Ribble Valley Borough Council
Housing & Development Control

Application no: **3/2021/0760**

Address: **Springwood Drive Whalley BB7 9XL Phase 2 Lawsonsteads**

The Local Highway Authority have viewed the plans and highway related documents and have the following comments to make:

AA7403C Clitheroe Road
Whalley
HOUSE TYPE E
4B8P

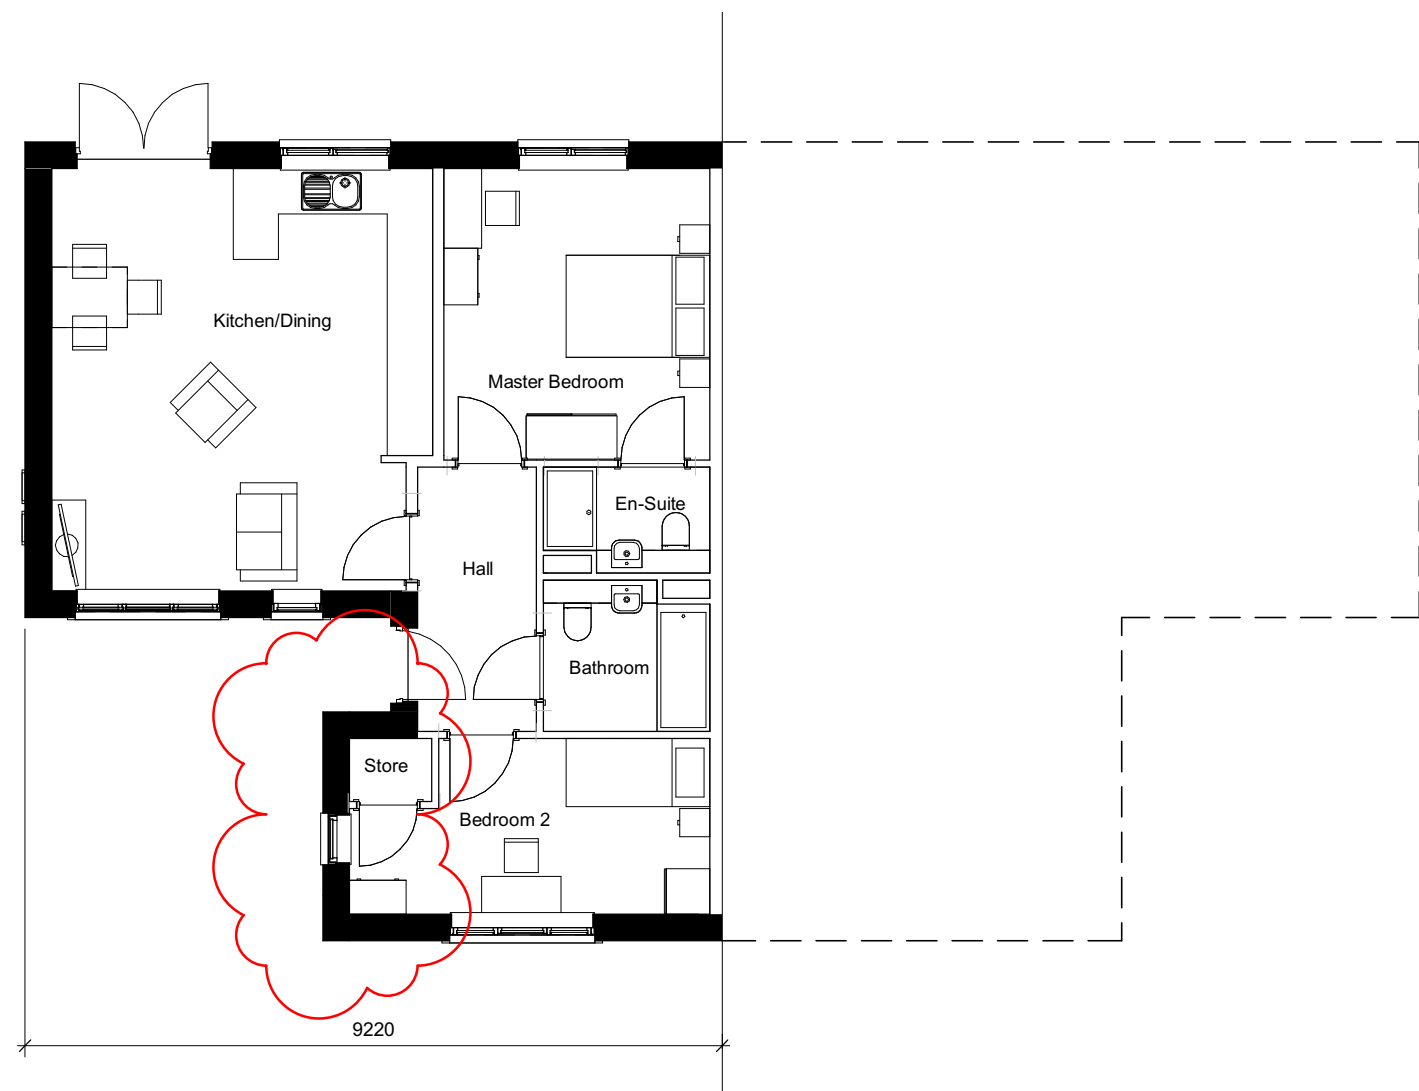
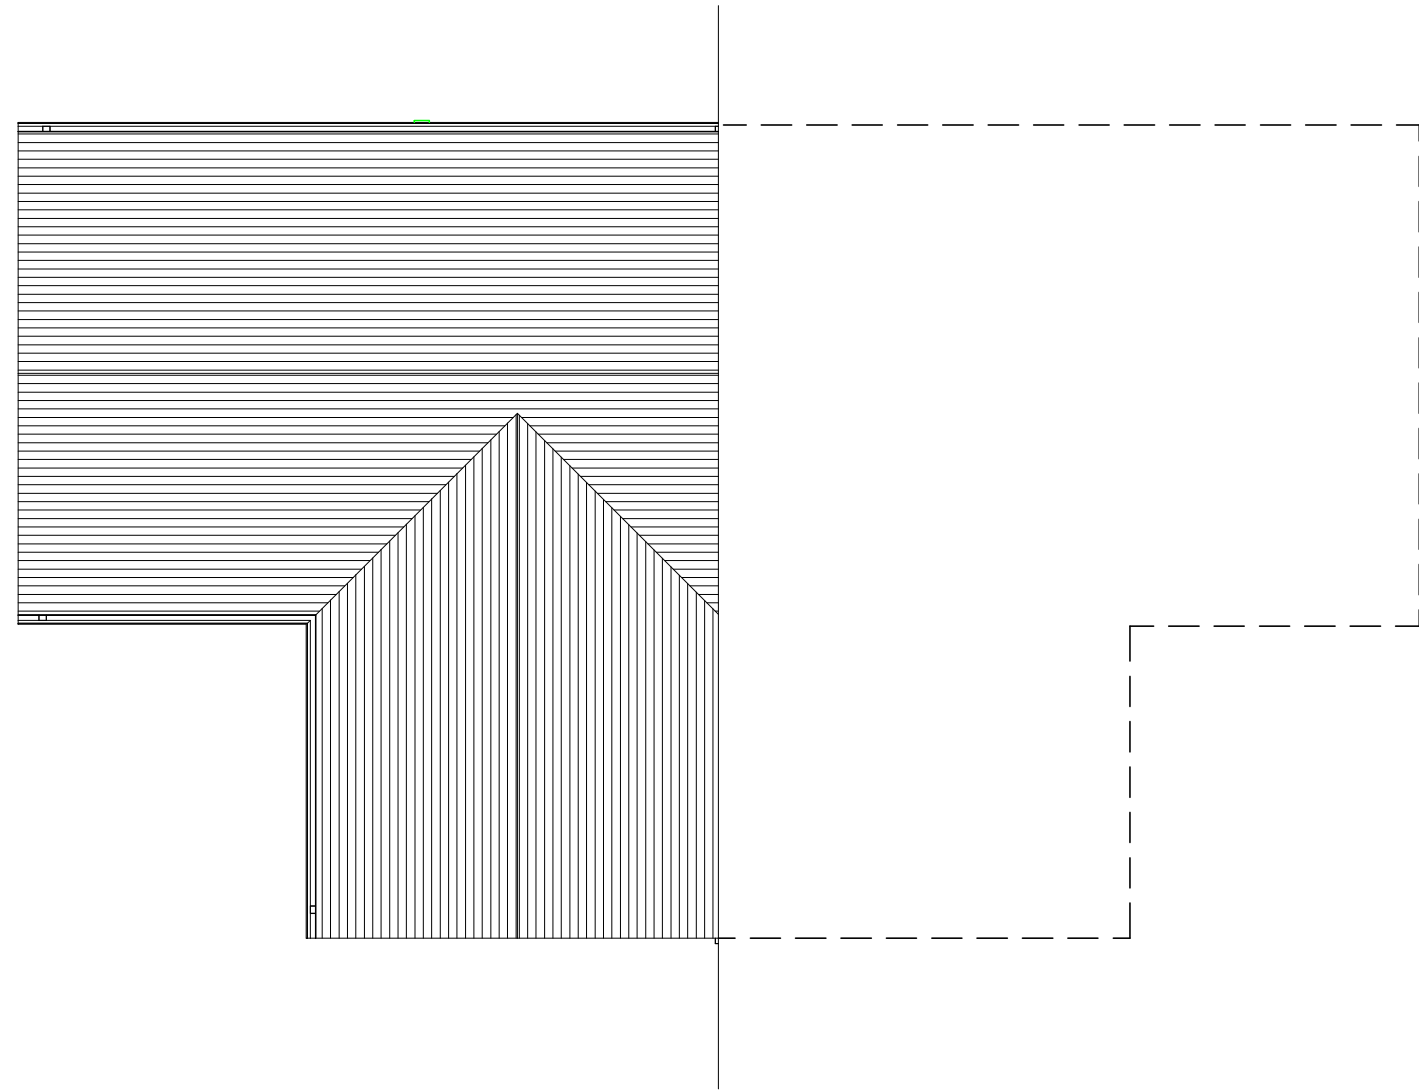
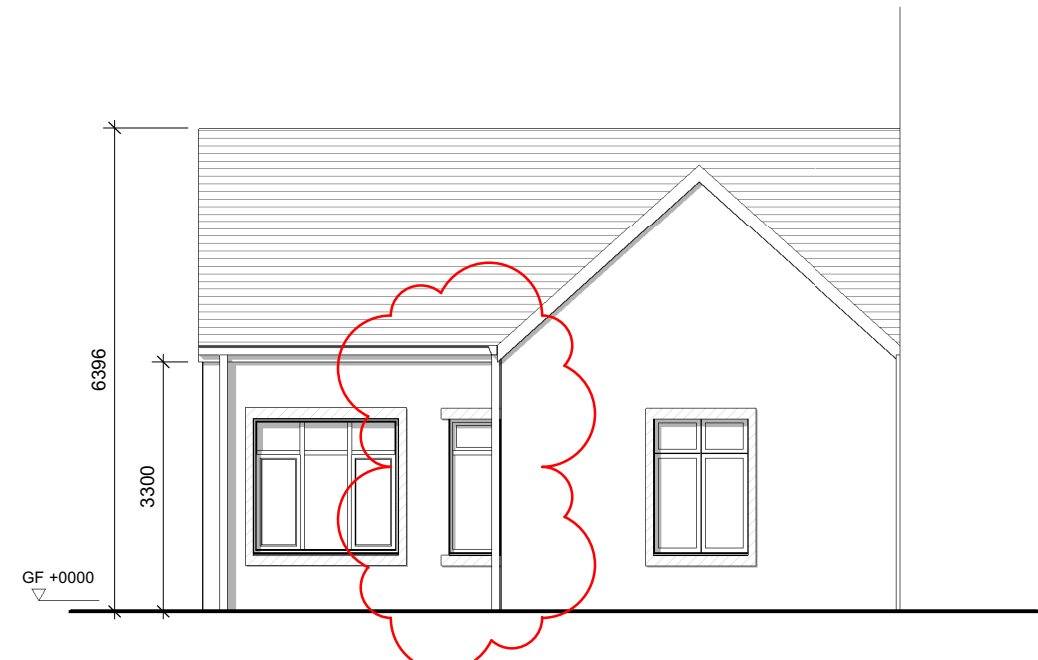
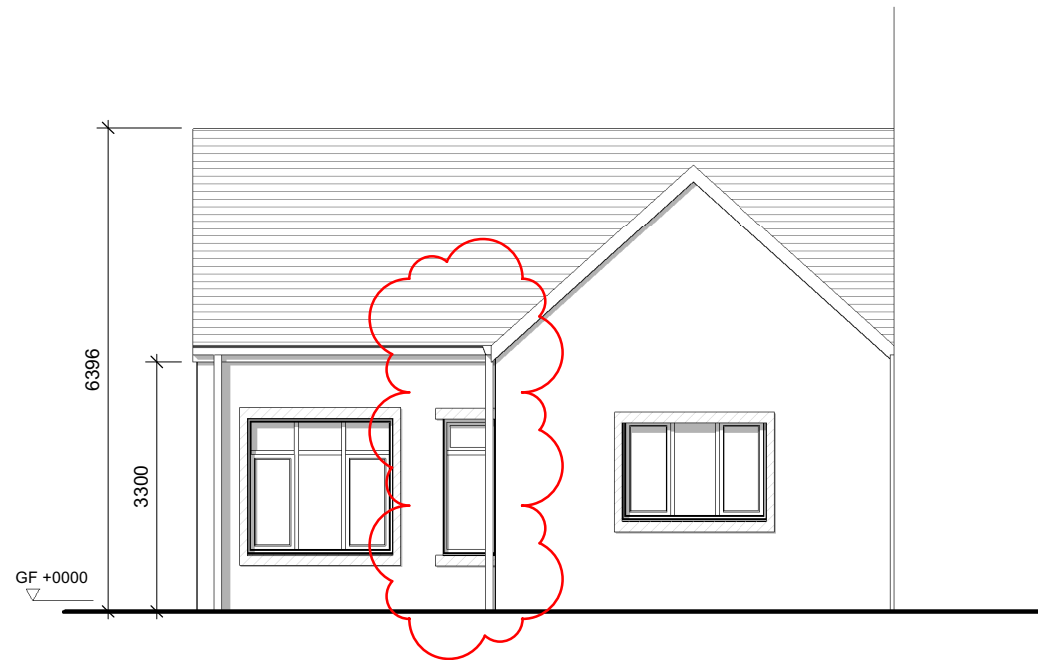
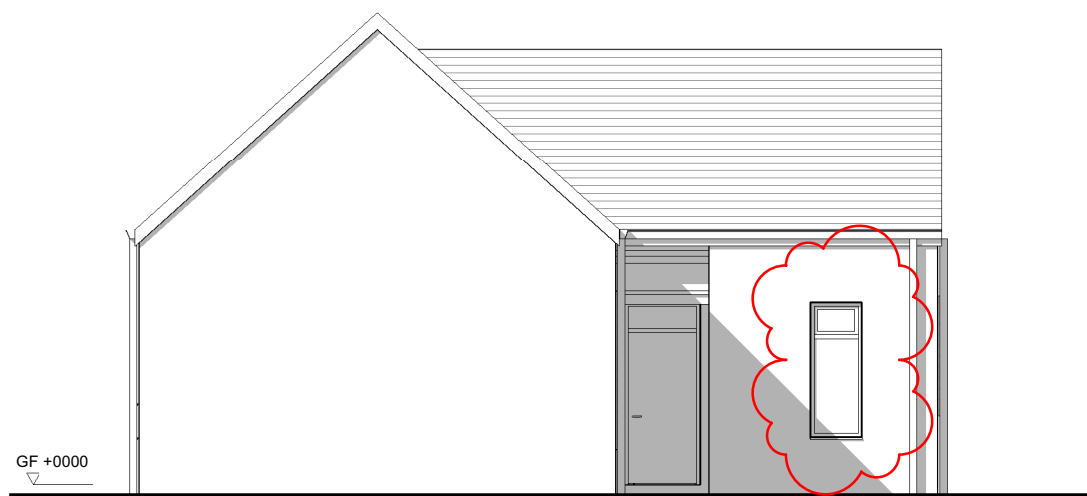
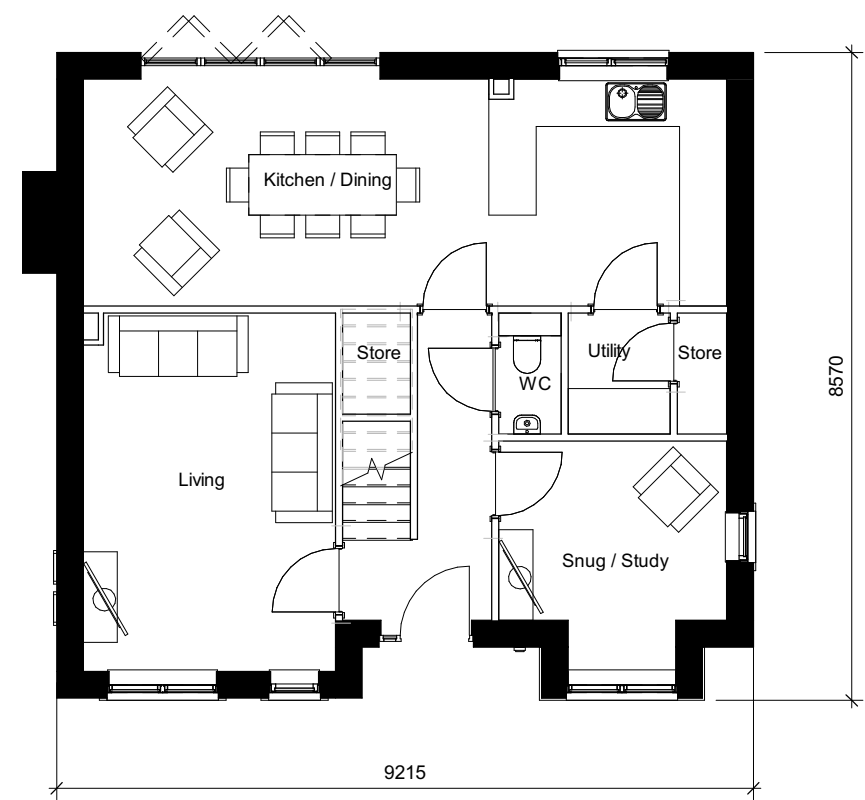
The LHA are aware that Plots 79, 86, 99, 102, 109 and 113 will change from a 3-bed to a 4-bed dwelling. For the Plots to comply with the Joint Lancashire Structure Plan, the LHA require a 4-bed dwelling to provide 3 car parking spaces.

The LHA have reviewed PRP drawing number Rev F titled Proposed Site Plan and understands that Plots 86, 102, 109 and 113 are able to provide an additional space on the driveway which complies with the LHAs guidance. However, Plots 79 and 99 can only provide 2 spaces- one space on the driveway and one space in the single garage. The LHA, as a result, require a revised plan showing these Plots are able to provide 3 car parking spaces.

The need for, in particular Plot 79, to provide 3 car parking spaces to fully comply with the Joint Lancashire Structure Plan is important because the dwelling is located adjacent to a turning circle which will be used by delivery and emergency vehicles when visiting neighbouring dwellings. Therefore, the LHA are concerned that a shortfall in parking in this location is likely to lead to vehicles parking in the turning head making the turning head unusable. This could lead to large vehicles having to reverse a significant distance to the next turning head, to be able to exit the site in a forward gear, which will be detrimental to highway safety.

As a result, the LHA require the Applicant to provide a revised plan showing that the Plot is able to provide 3 car parking spaces or the LHA advise that the Plot remains a 3 bed dwelling as original planned under application reference 3/2018/0914.
